Department of Transportation

Traffic & Safety - Permits Unit

May 19, 2026

RE: Hillpointe Apartments SDP (PPR2613)

HILLPOINTE APARTMENTS AT PETERSON
SECONDARY ACCESS PLAN

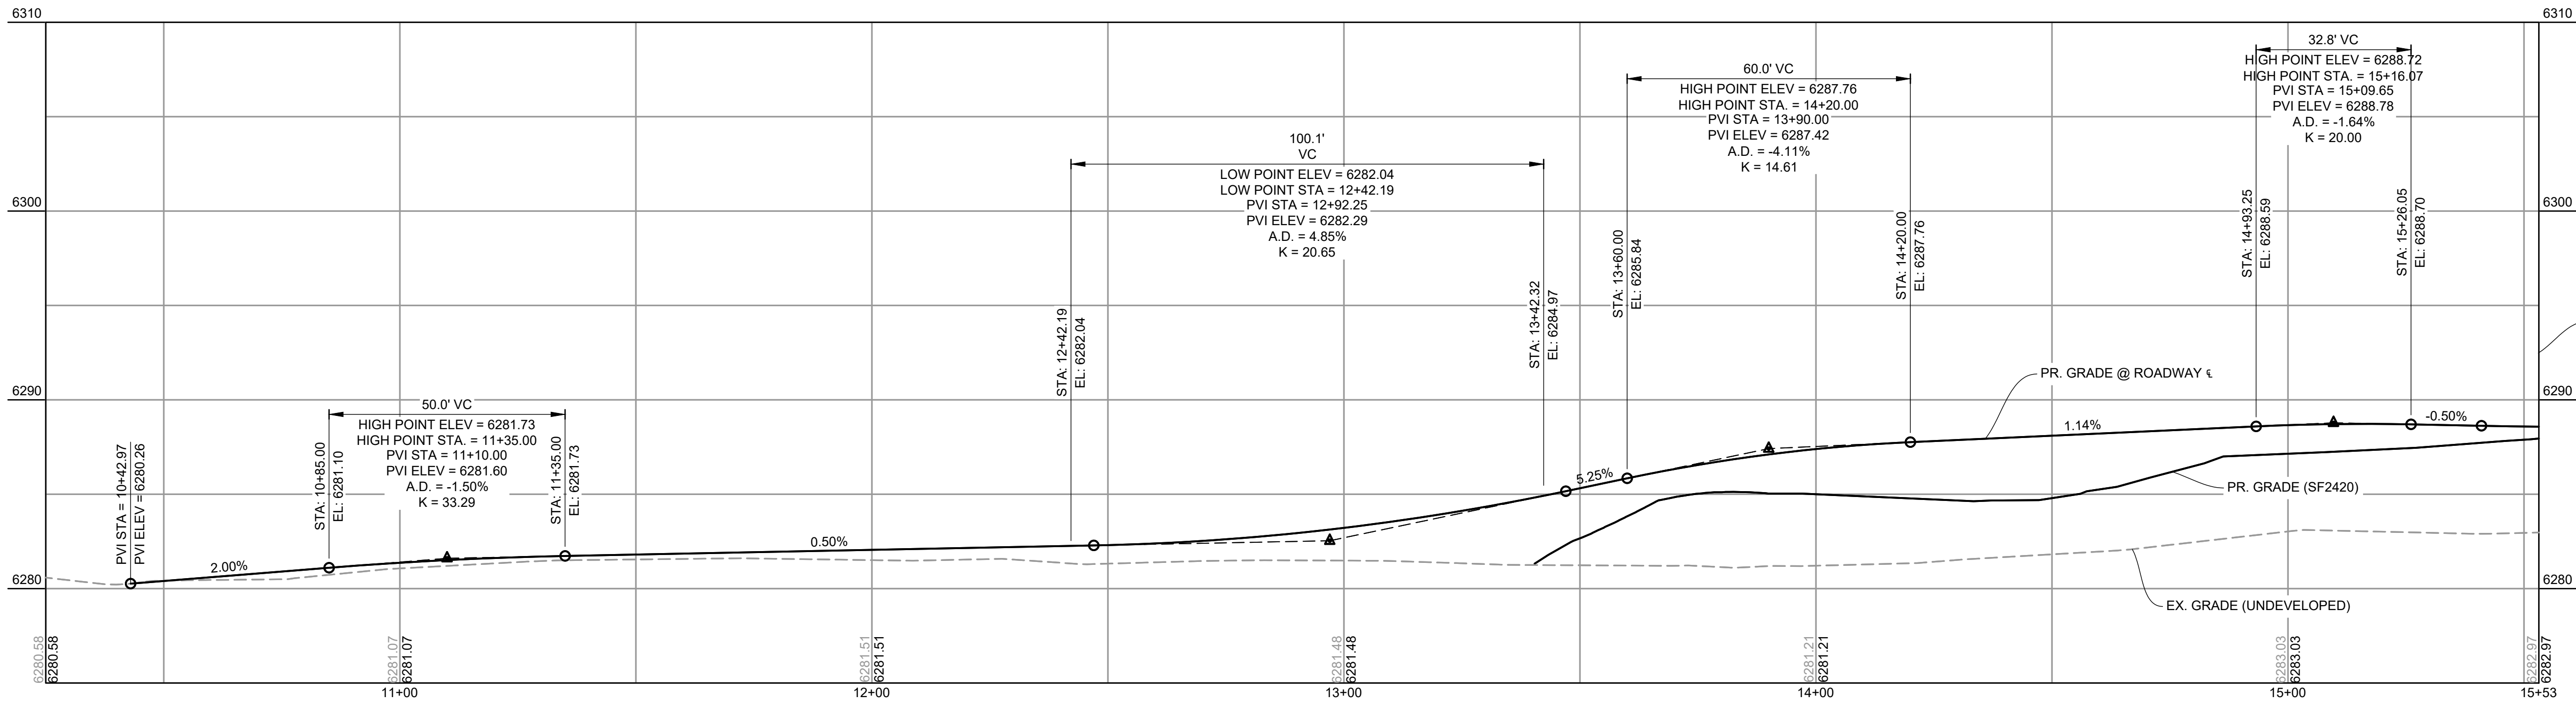
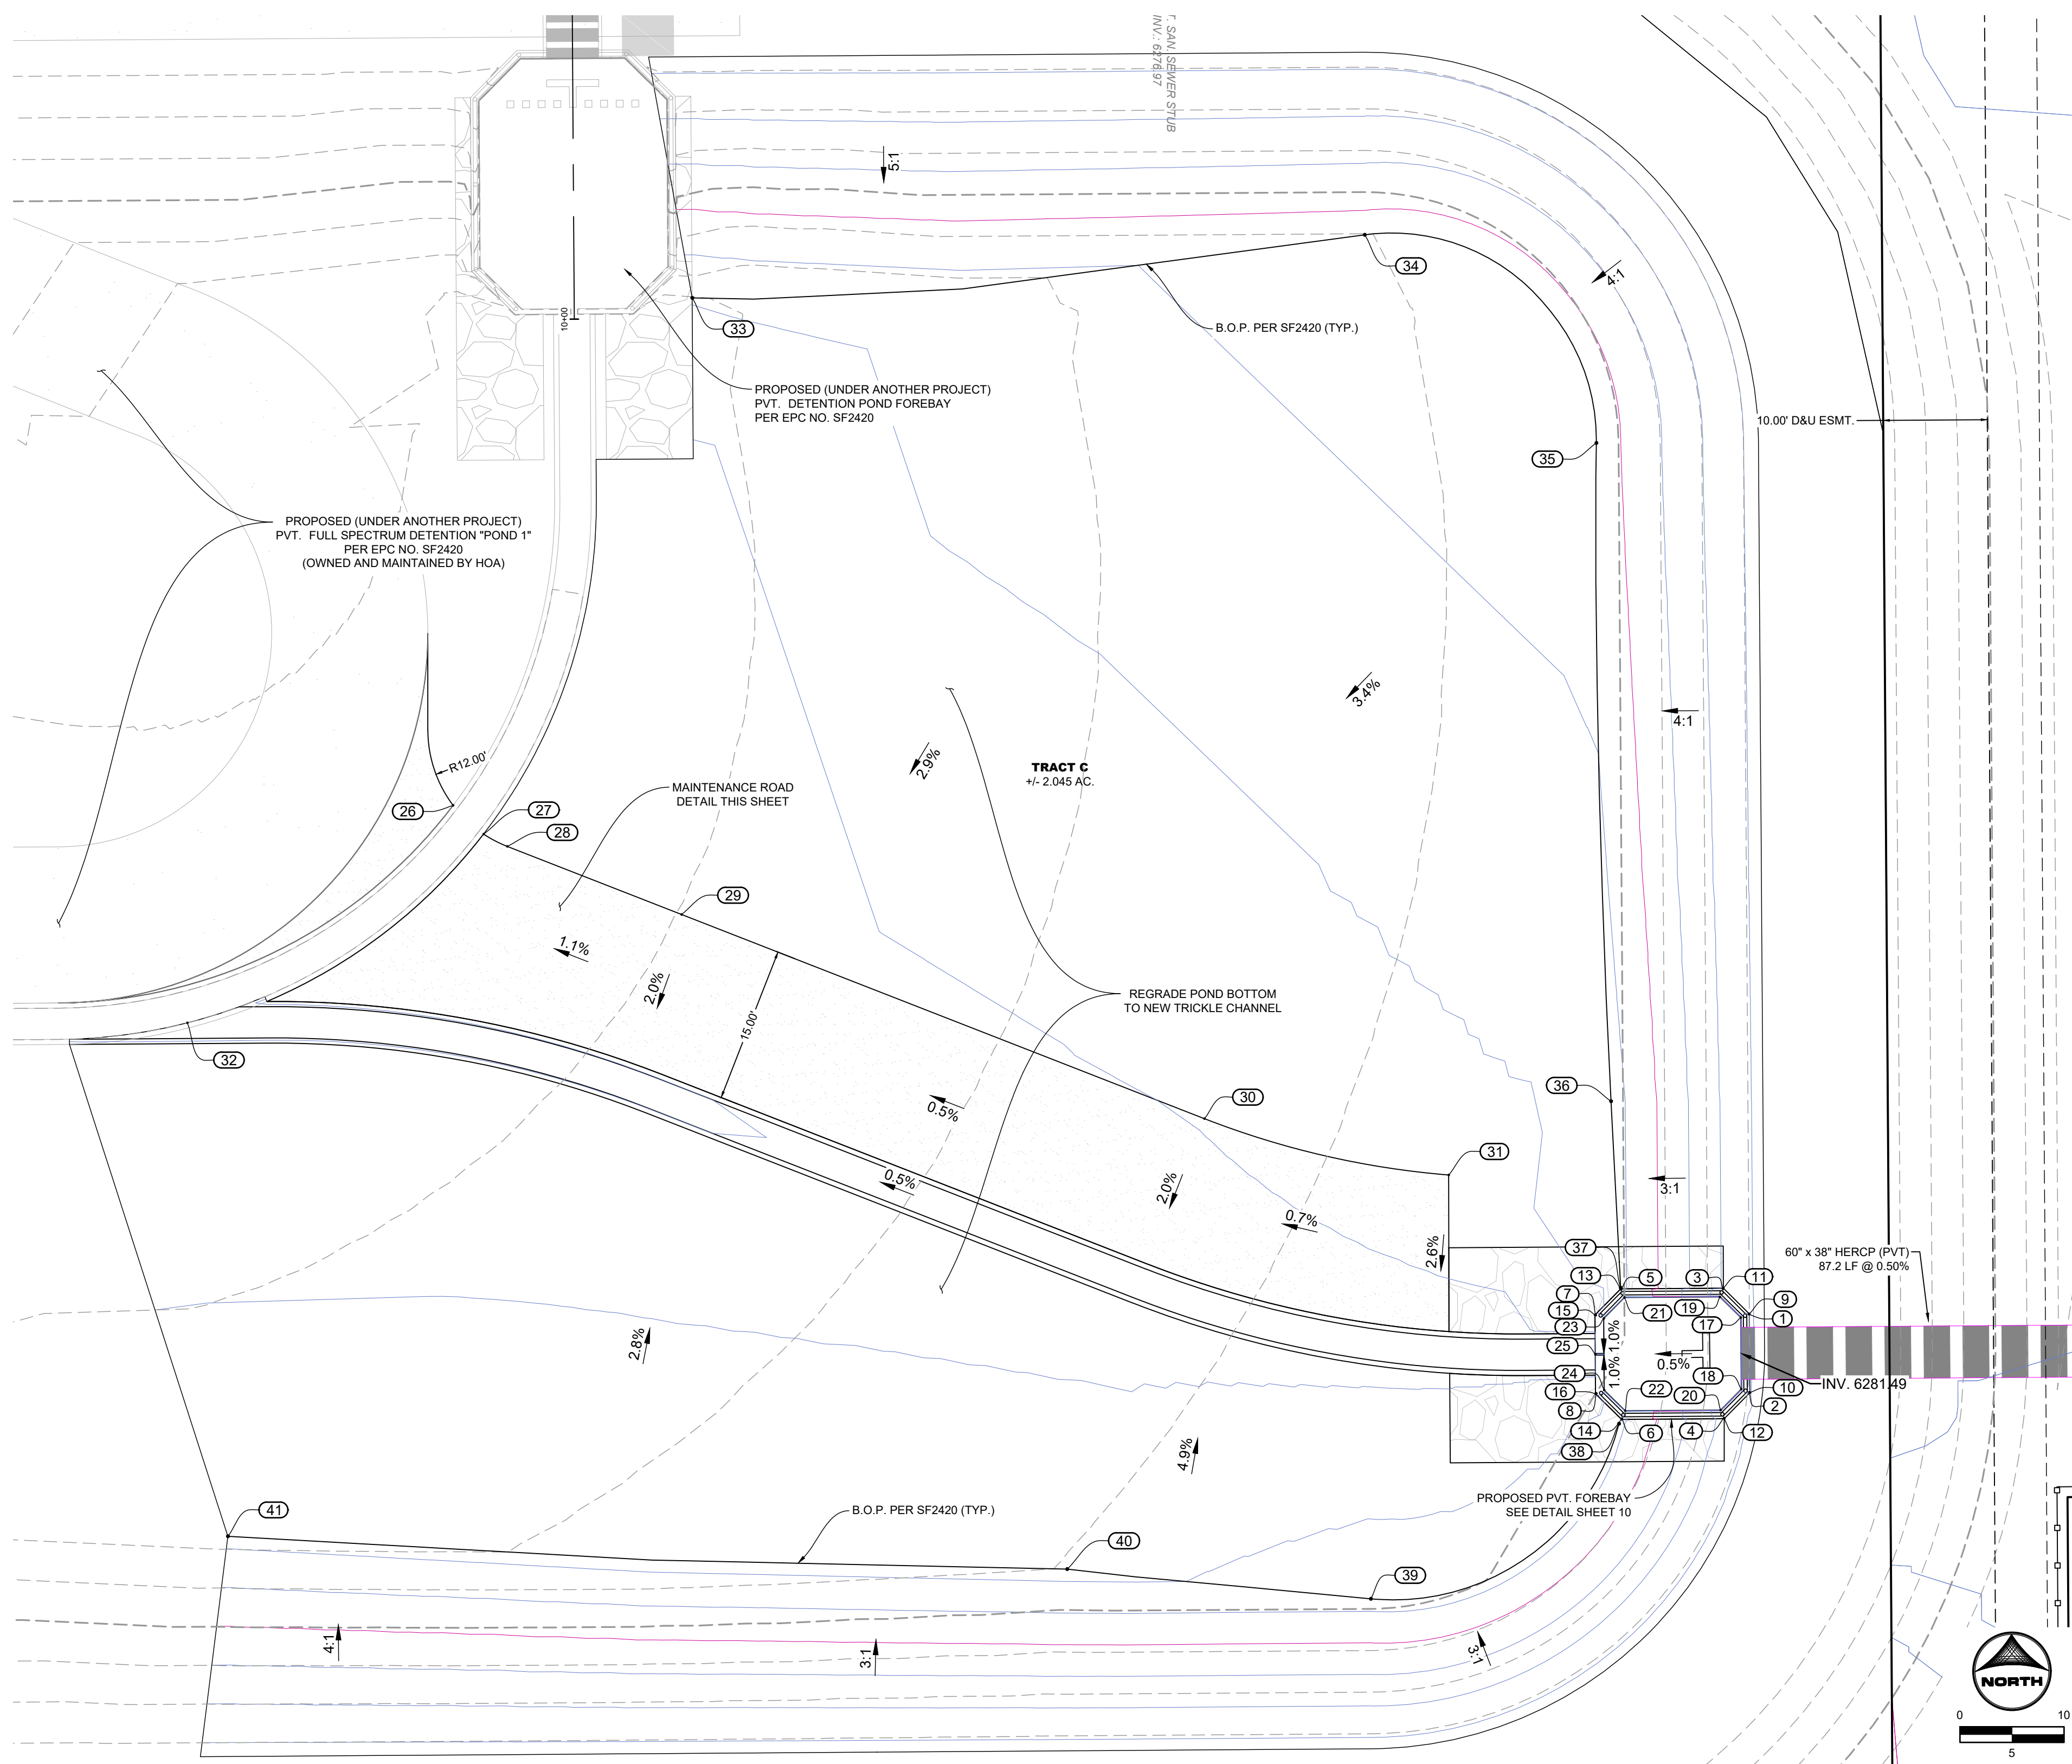
"The submitted Proposed access to the development is provided via one full-movement access onto the future extension of Meadowbrook Parkway (referred to as Site Access). This access is anticipated to be shared with the future adjacent Cimarron Hills development. Additionally, it is noted that the existing intersection of Peterson Road with Panamint Court will be converted to a right-in/right-out intersection and serve as an emergency-only access for the proposed development."

Submit a document for review from Emergency Services requesting an emergency access at this location and the reason for the request.

CDOT will need to review and approve construction plans for the access conversion to right-in/right out. These plans shall be submitted with the access permit application.
